24 April 2020

**Application by Highways England for an Order Granting  
Development Consent for the M25 Junction 10/A3 Wisley  
Interchange**

**Request for further information**

**Our Clients: Messrs Mr and Mrs P Young [REDACTED]  
Mrs A Barklam [REDACTED]  
Miss B Kendrick [REDACTED]**

Figure 4.1 – Proposed amendments to the visibility splay on Old Lane/Elm Lane corner (extract of dwg: HE551522-ATK-HGN-XX-SK-CH-000093_C01)

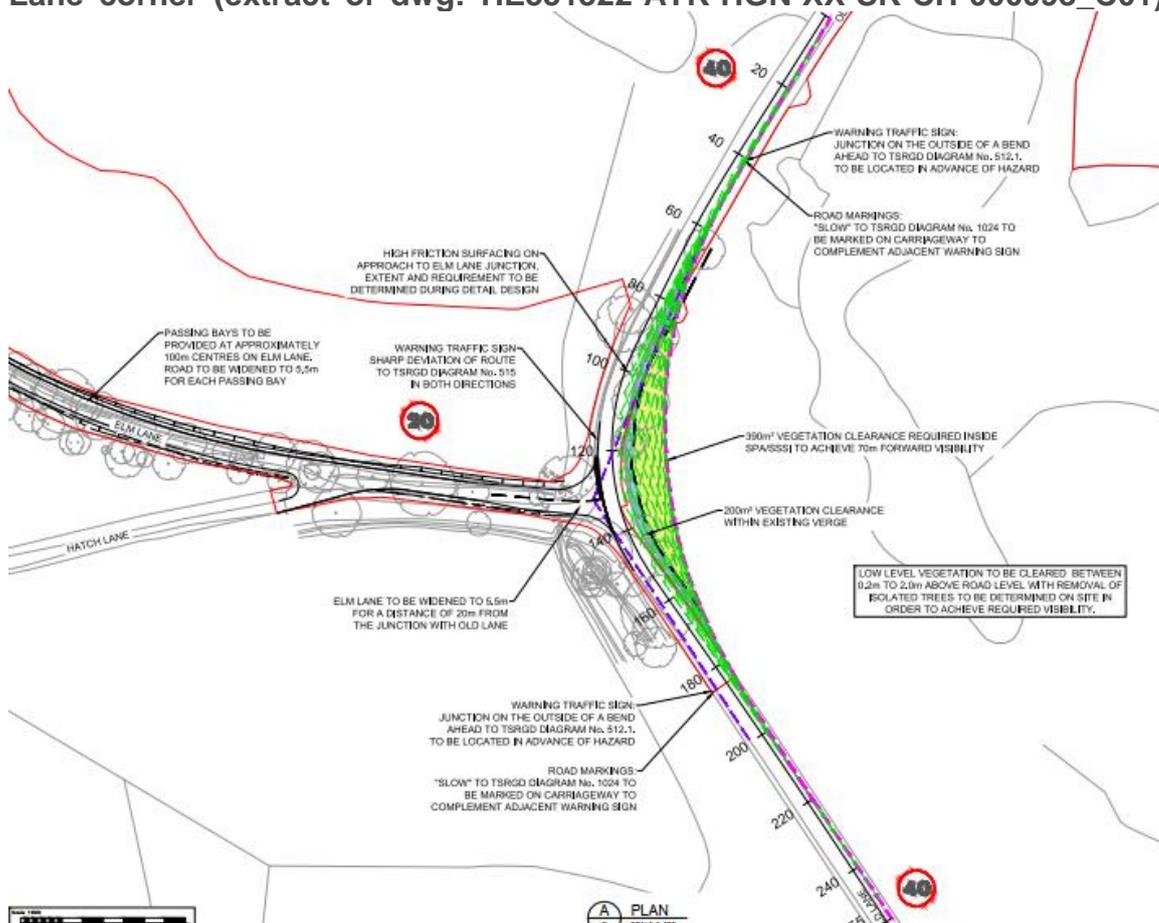
1. With regard to the proposed alterations to the junction of Elm Lane and Old Lane, the current proposal to paint "slow" on the road. This is considered completely inadequate. The design of the scheme will encourage greater speeding along the relevant section of Old Lane and this is potentially hazardous. As a minimum there should be rumble strips across the road, and/or anti-skid resistant surfacing and a speed activated warning sign.

We note that in Surrey County Council's (SCC) response to the Inspectors second written questions submitted on 18 February 2020, SCC has already raised concern at Paragraph 2.13.30 (d) that the entrance to Elm Lane may not be wide enough to safely allow traffic turning into Elm Lane from Old Lane to pass traffic exiting Elm Lane. This needs careful analysis and design.

Figure 5.1 – Proposed revised layout of Wisley Airfield construction compound following Change 9 (extract of dwg: HE551522-ATK-LDC-A3_L1-DR-ZL-096502)

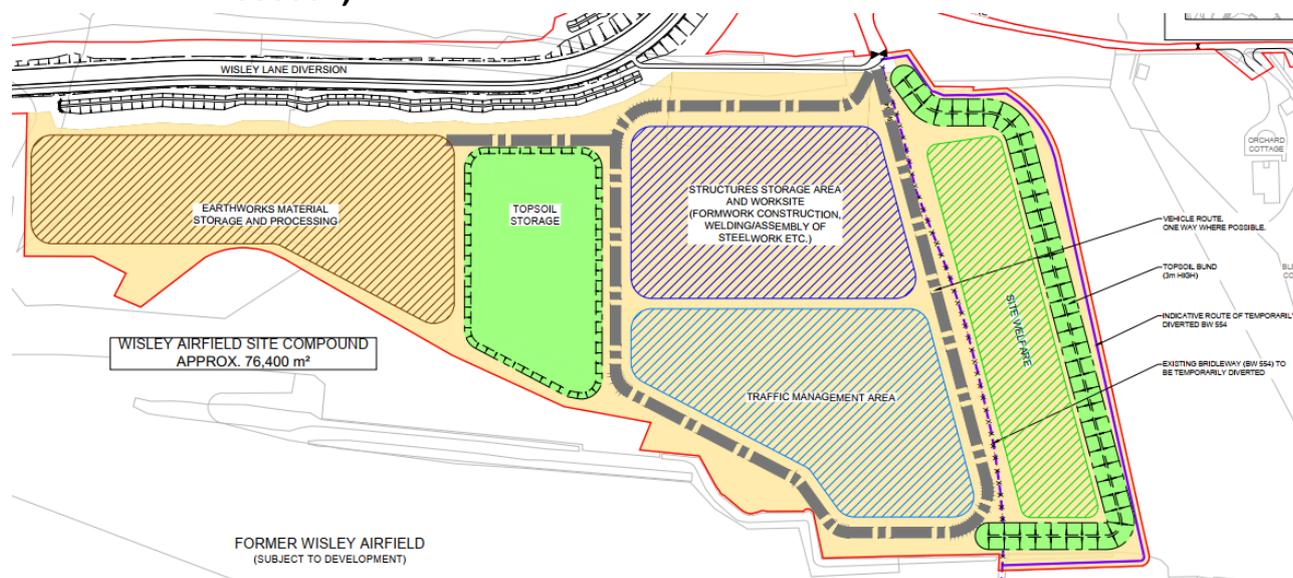
My Clients are extremely concerned about how the use of the proposed construction compounds on the adjoining Wisley airfield will impact upon them. We understand from the Project Manager that it is proposed to set up a working group which the residents of Elm Lane and their representatives would be invited to join so that the impact of the use of the compounds can be monitored. Whilst this is a welcome suggestion and my clients would be very keen to participate in such a group, nonetheless the concern remains that this may give them little practical influence when the physical impact of the works is at its greatest.

In particular, our clients are concerned about the following matters:-

- a) The hours of operation and the use of floodlighting.
- b) The proposed height of the bund is 3m. It is recognised that this will provide a useful barrier, it could potentially be higher and /or topped with an acoustic fence.
- c) It will be necessary to consider weed control on this earth bund as the prevailing wind will blow weed seeds into gardens of all of the residents' properties.
- d) There is a general concern about the location of the compound as had it been located further to the west, the impact of the residents would have been significantly reduced.
